Development Review Board (DRB)
Review Comments
Utility Development Section
Reviewer: Blaine Carter, P.E.
Phone: 505.415.9188

DRB Project No: PR-2020-003485	Date: 09/01/21	Item No: #12
Zone Atlas Page: J-14	Legal Description: Lot(s) TRACT A- & LOT 8-A, BLOCK N, BERNALILLO COUNTY METROPOLITAN COURT & MANDELL BUSINESS RESIDENCE ADDITION Location: 412 MARBLE/804 5TH ST between LOMAS BLVD and MARBLE AVE	
Request For: PS-2021-00103 – SKETCH PLAT

ARCH + PLAN LAND USE CONSULTANTS agent for **BERNALILLO COUNTY METROPOLITAN COURT** requests the aforementioned action(s) for all or a portion of: **TRACT A-1 & LOT 8-A, BLOCK N, BERNALILLO COUNTY METROPOLITAN COURT & MANDELL BUSINESS RESIDENCE ADDITION** zoned MX-M, MX-H and MX-FB-UD, located at **412 MARBLE/804 5TH ST** between **LOMAS BLVD and MARBLE AVE** containing approximately 3.9 acre(s). (J-14)

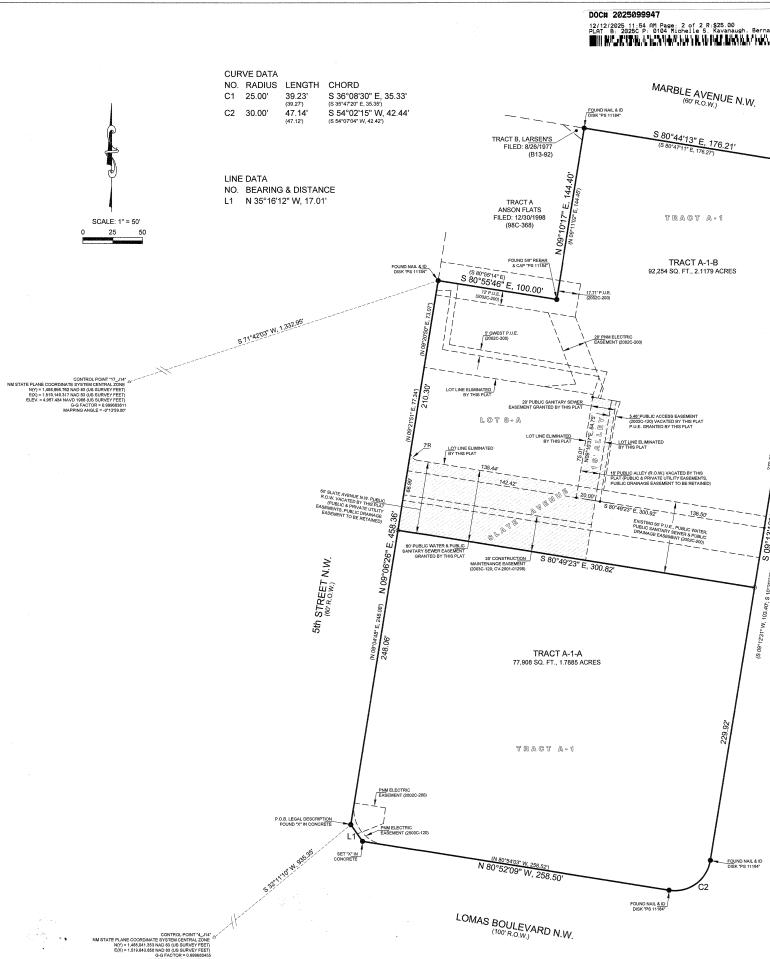
1. Coordinate with NM811 on the field location of the public water and public sewer mains. Once the lines are located, survey the locations and show those on the plat. Public water and public sewer easements are required prior to approval over all existing public water and public sewer mains.
2. No objections to the vacation provided the required public water and public sewer easements are provided. Note that the submitted plat does not appear to include easements under the existing right-of-way that is to be vacated, yet there are public mains in this location. This also applies to the alley that is proposed for vacation.

3. The Water Authority needs to have the ability to have operate and maintain the existing infrastructure.
4. As a condition of approval, a minimum 25' public waterline and sanitary sewer easement is required.
5. Coordination with Field and Collections may be helpful to understand the access requirements.
